From: Simon Davis
Sent: 17 September 2019 09:59
To: Planning Scanning
Subject: FW: Planning Consultation on: P/70/19/RES

From: Daniel O'Shea ([REDACTED])
Sent: 16 September 2019 12:49
To: Simon Davis ([REDACTED])
Cc: Adrian Barker ([REDACTED])
Subject: RE: Planning Consultation on: P/70/19/RES

Final Site Plan

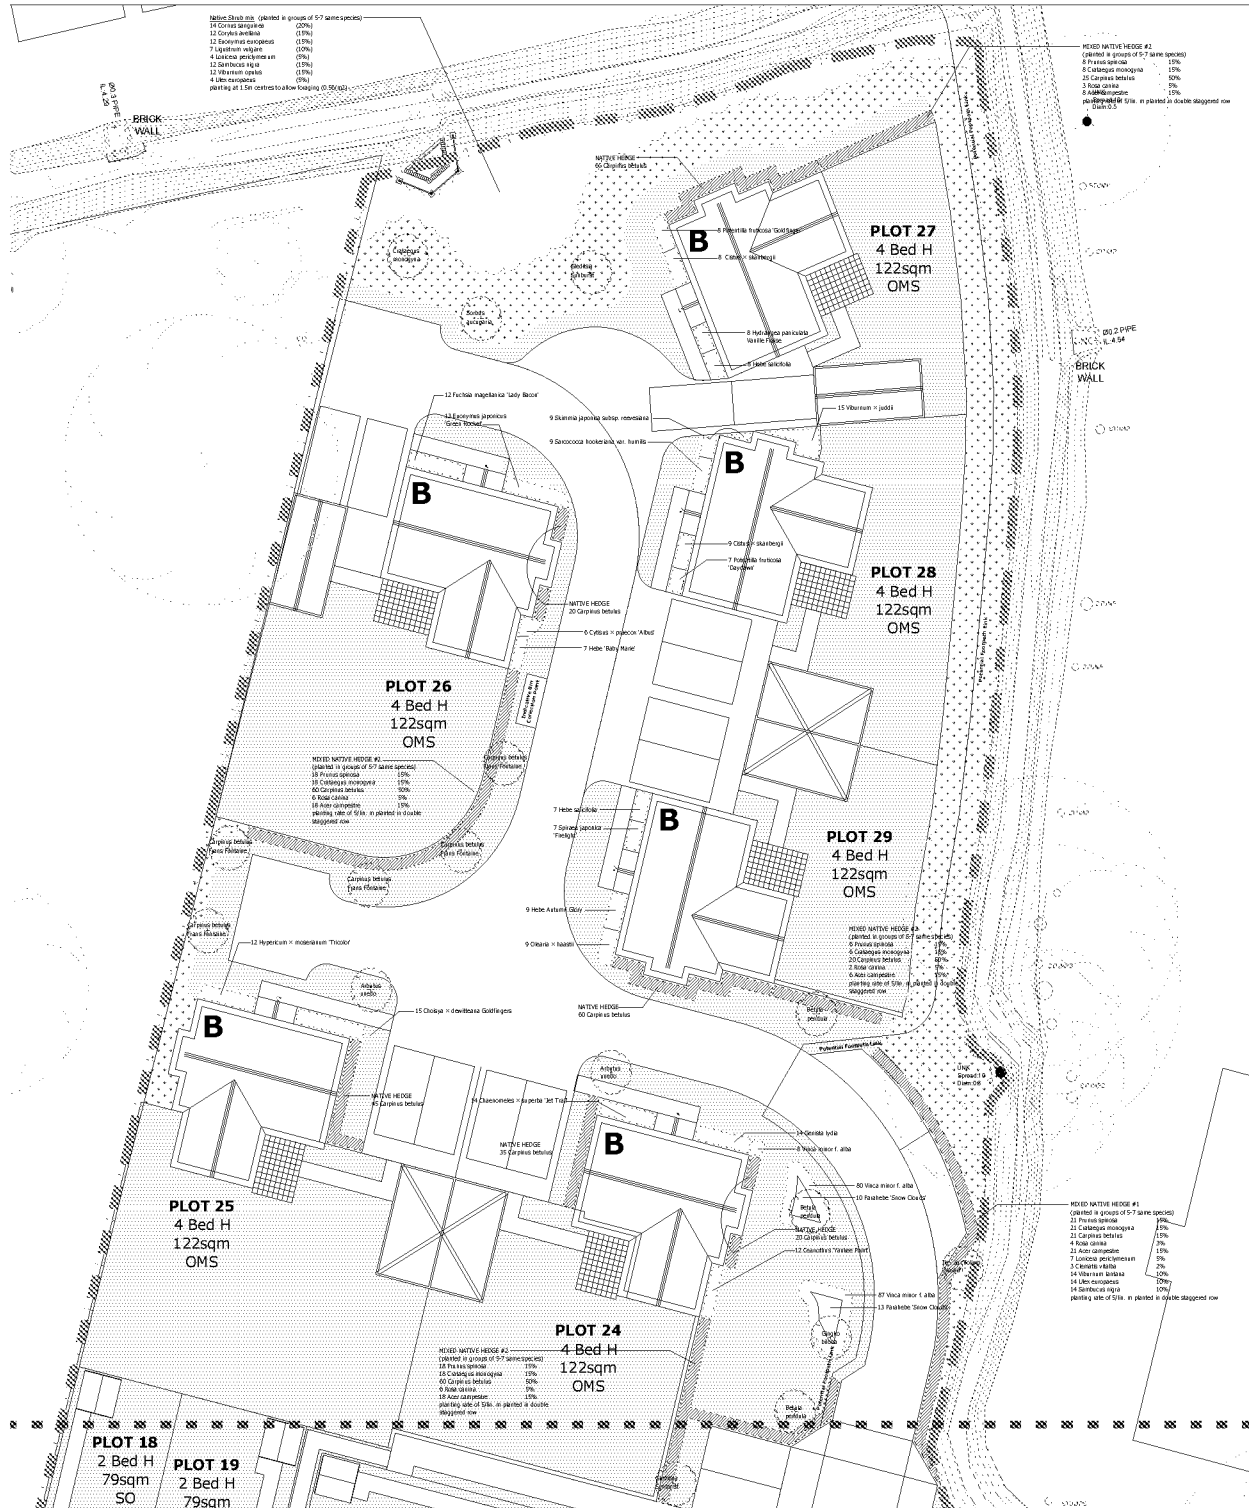
Footpath connecting this site and P/125/14/PL: Agreed in part. This does not need to be provided at this time. However, you need to show your footpath as being able to meet with the route as agreed on the Crayfern plans. See attached plan. -- we will revise to show connection at the point on Crayfern's plan instead, fortunately our route runs adjacent to the point of connection proposed

Plots 34/35 & 36/37: I agree that this is an unacceptable relationship to these existing houses. -- Plot 35 has a side elevation with no windows facing the rear elevation of plots in Brooks Close, but is 11.5m away from the main house at the closest point and is deliberately offset, so as not to fully obscure all views out from the existing property. It is accepted that there may be some loss of evening sunlight to neighbouring gardens, perhaps we could provide a sun path analysis to gauge the extent of this impact?

Plots 36 & 37 have a side elevation intentionally aligned with the road between existing adjacent properties. The existing properties have side elevations adjacent to the boundary, we are repeating this arrangement, but in the space between so as not to obscure light into existing principal elevations or gardens. It is felt this is an acceptable relationship, as would be found in common arrangements of properties that sit side-by-side.
